# CITY OF ALBUQUERQUE

September 11, 2013

**Re: Garcias Kitchen Food Prep & Catering  
Grading and Drainage Plan  
Engineer's Stamp Date 8/19/2013 (J13/D096)**

GRADING AND DRAINAGE PLAN

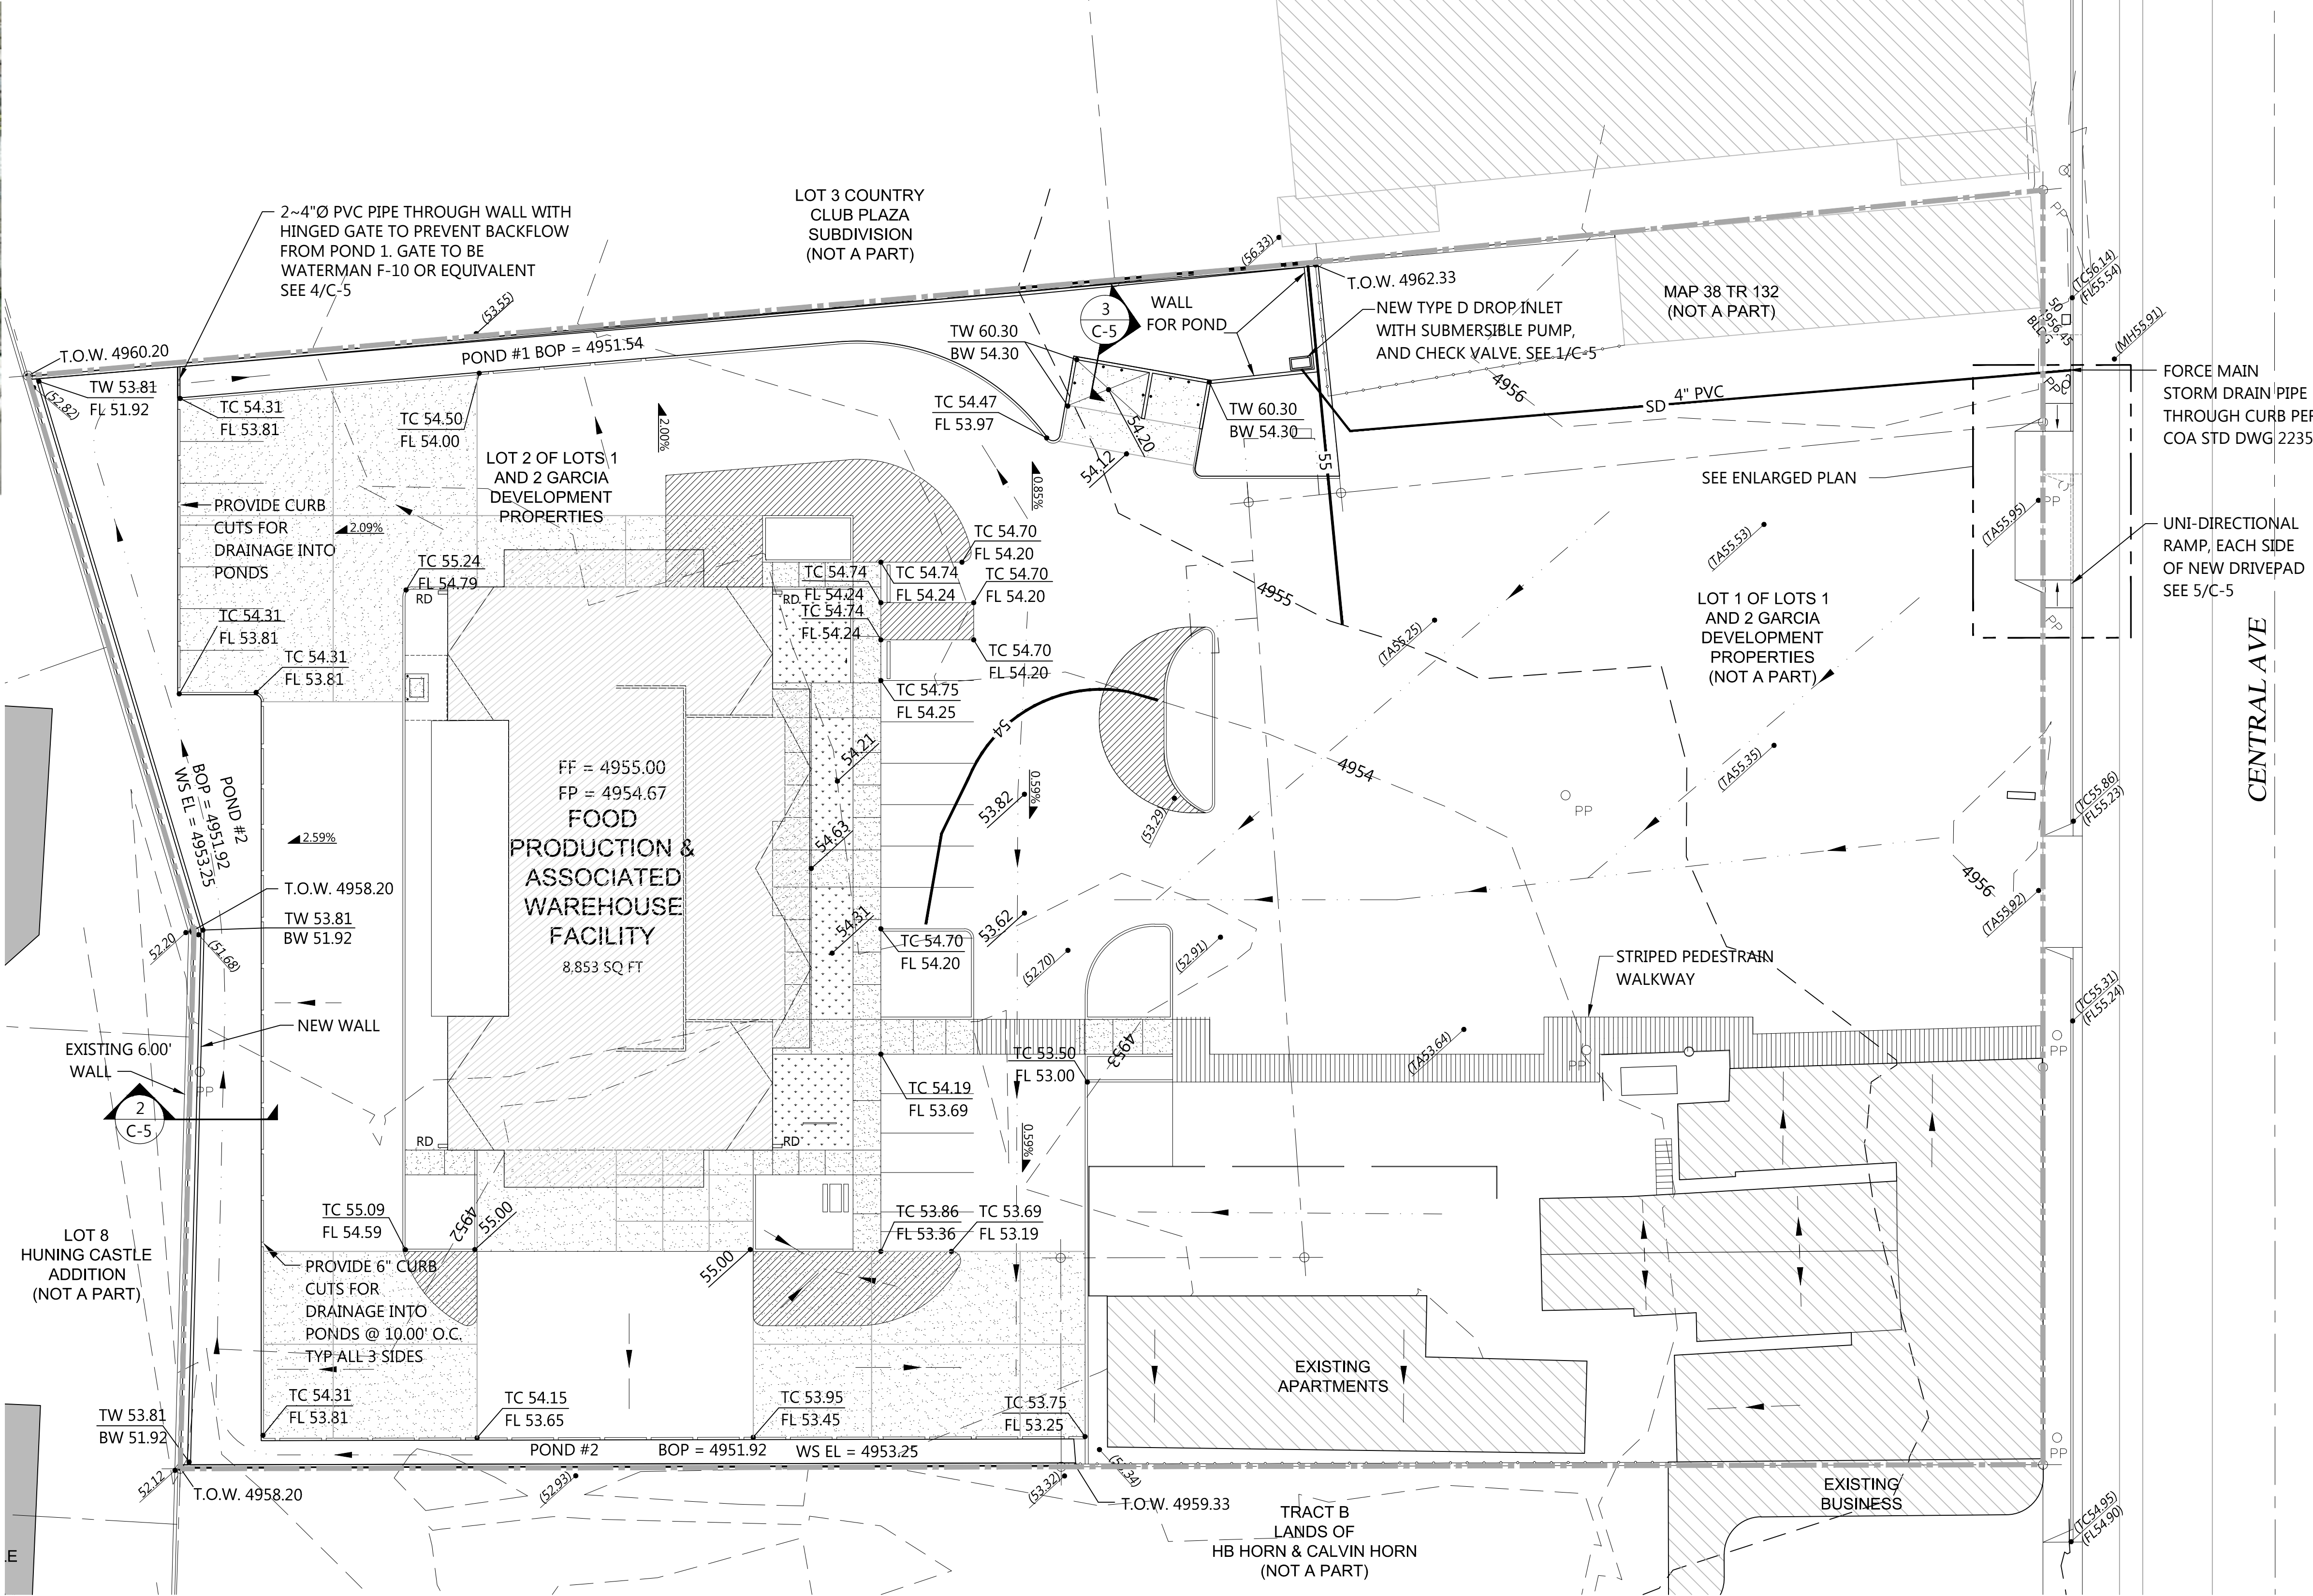
- Please quantify the flows entering from the northwesterly property.
- Clarify existing and proposed spot elevations along the boundary lines.
- Show pond volume calculations. The high water elevation is at 4952.22 and bottom of Pond 1 is at 4952.23. How much runoff is being intercepted by Pond 1?

- Provide 100-yr/10-day Volume calculations and WSEL.
- Please spot elevation for the trash area to assume that the runoff will drain to the center of the enclosure. Please include a note on the grading plan that floor drain will be routed to an oil water separator and then to Sanitary Sewer.

- Provide positive flow away from the building.
- Callout curb opening along the westerly and easterly ponds. Show the curb openings along the easterly pond.

DETENTION POND DETAIL

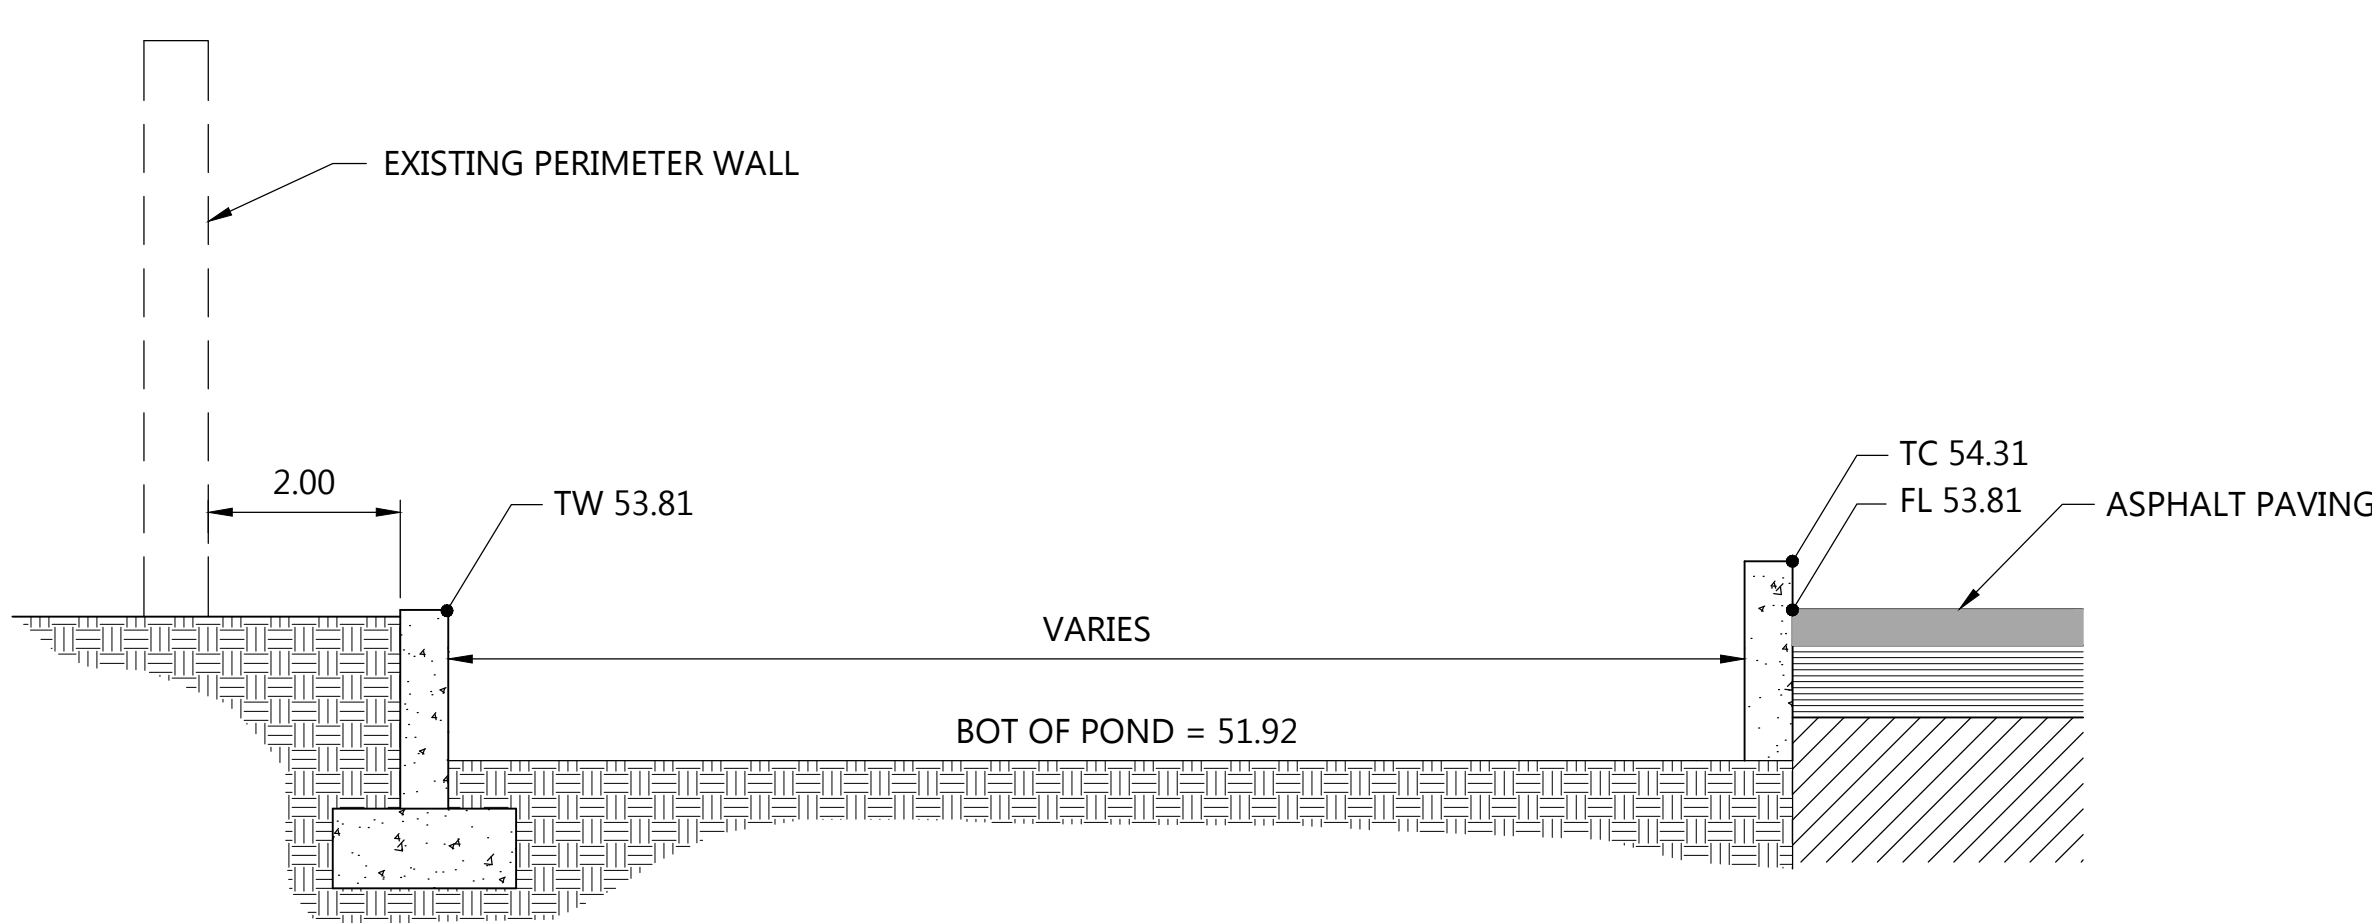
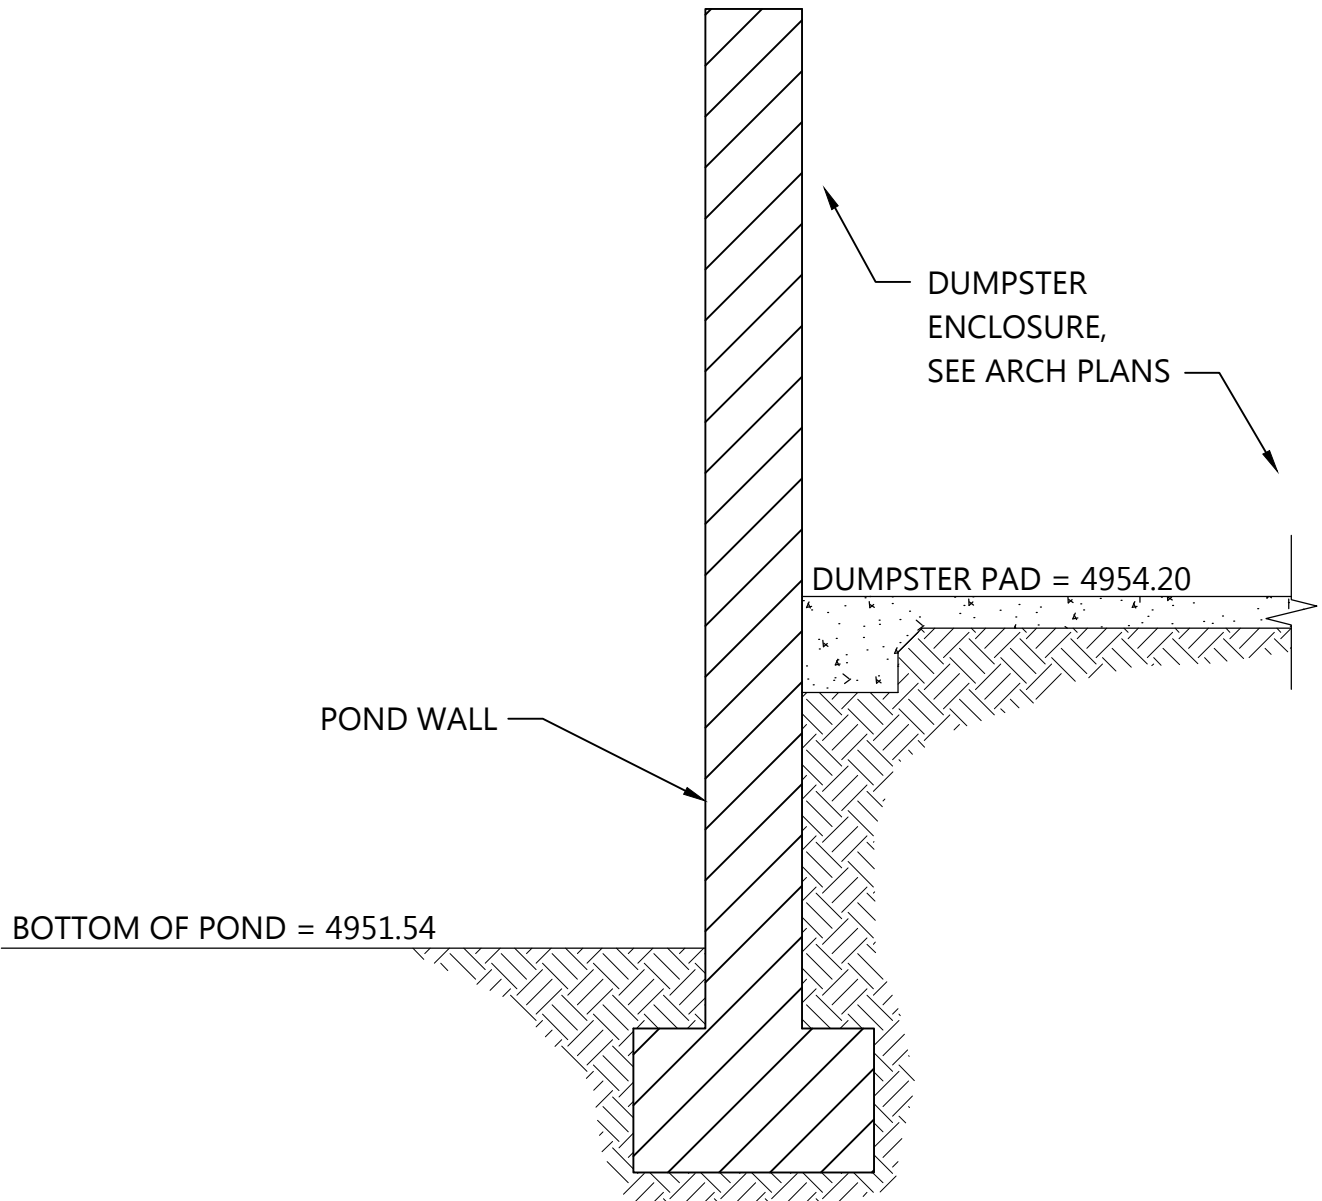
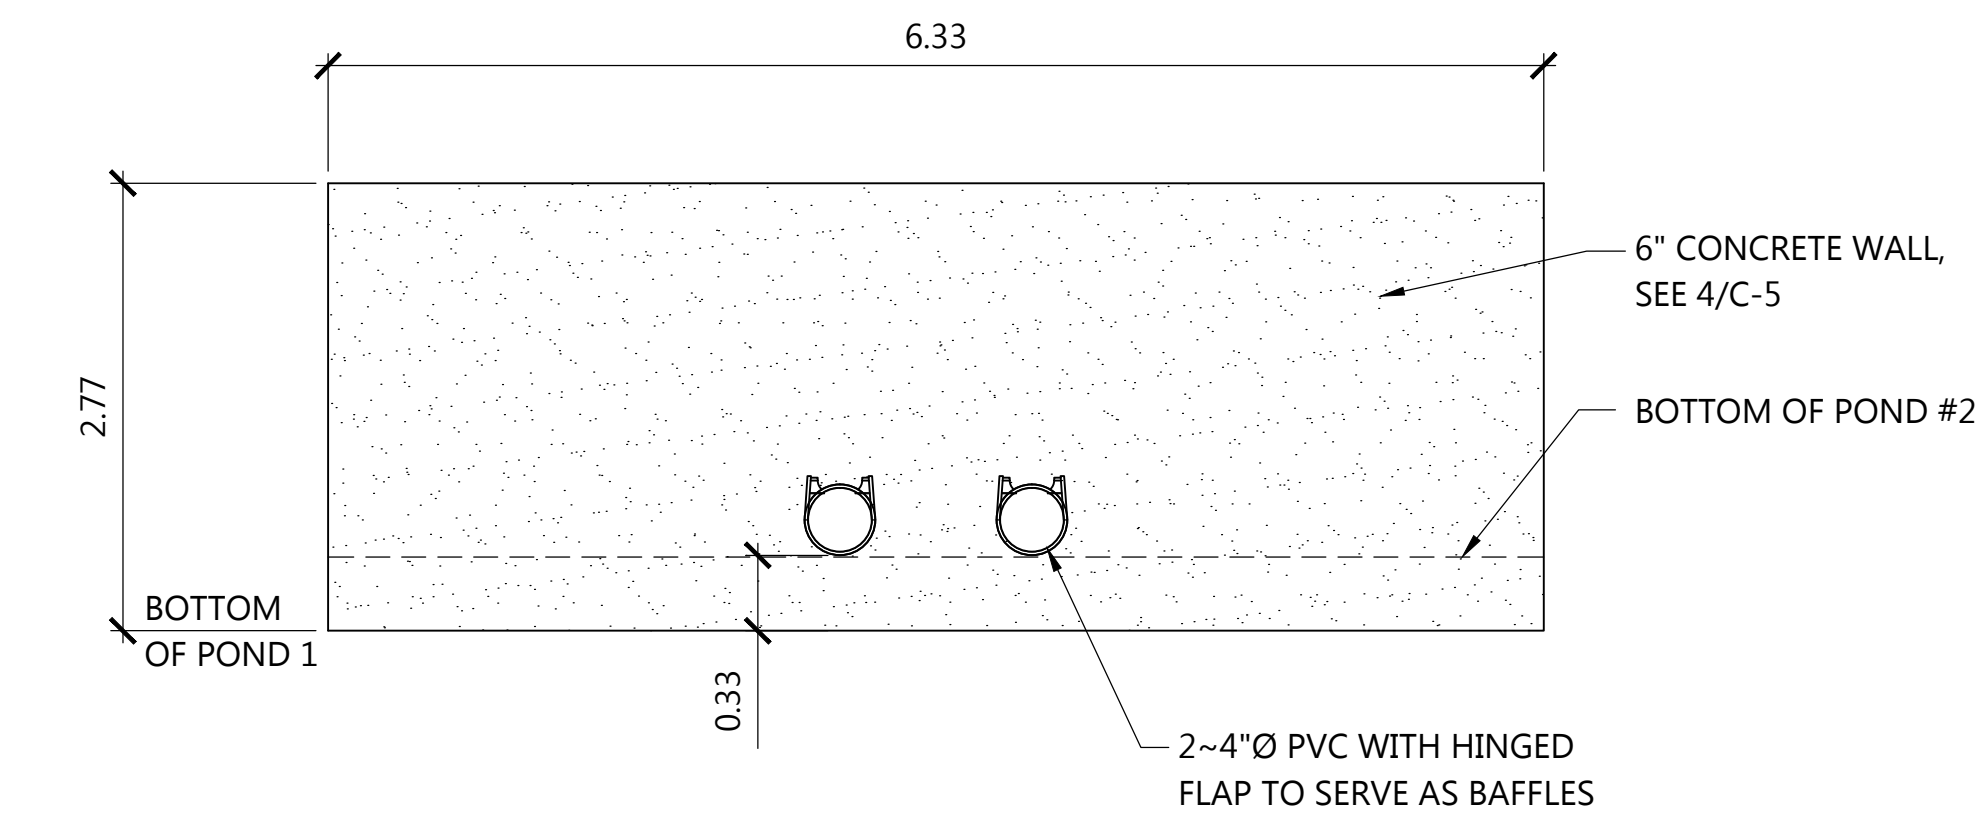
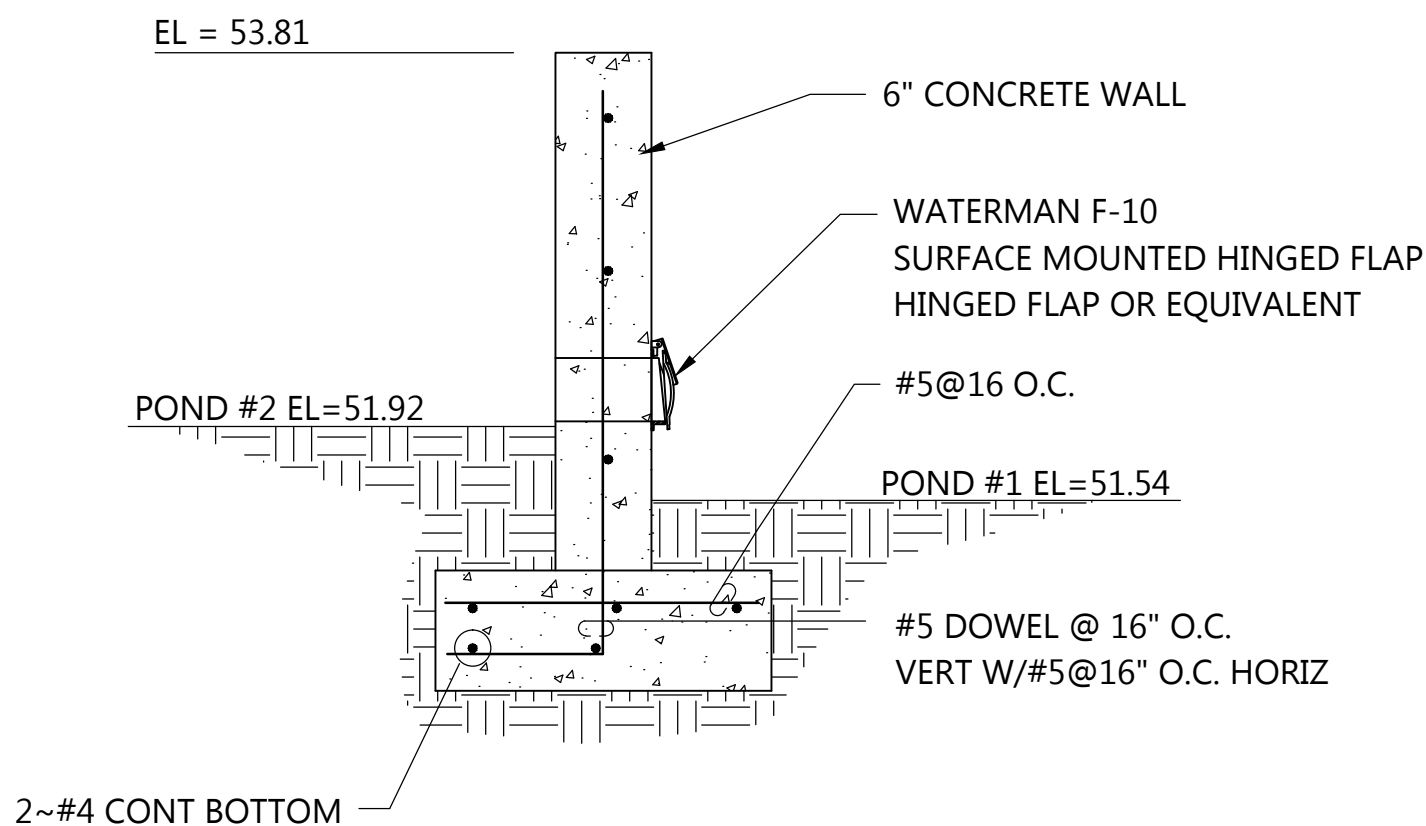
- Include sections at the pond locations to the east, west and to the south. Provide top and bottom of wall elevation for the proposed retaining walls. Will the retaining walls be waterproofed?
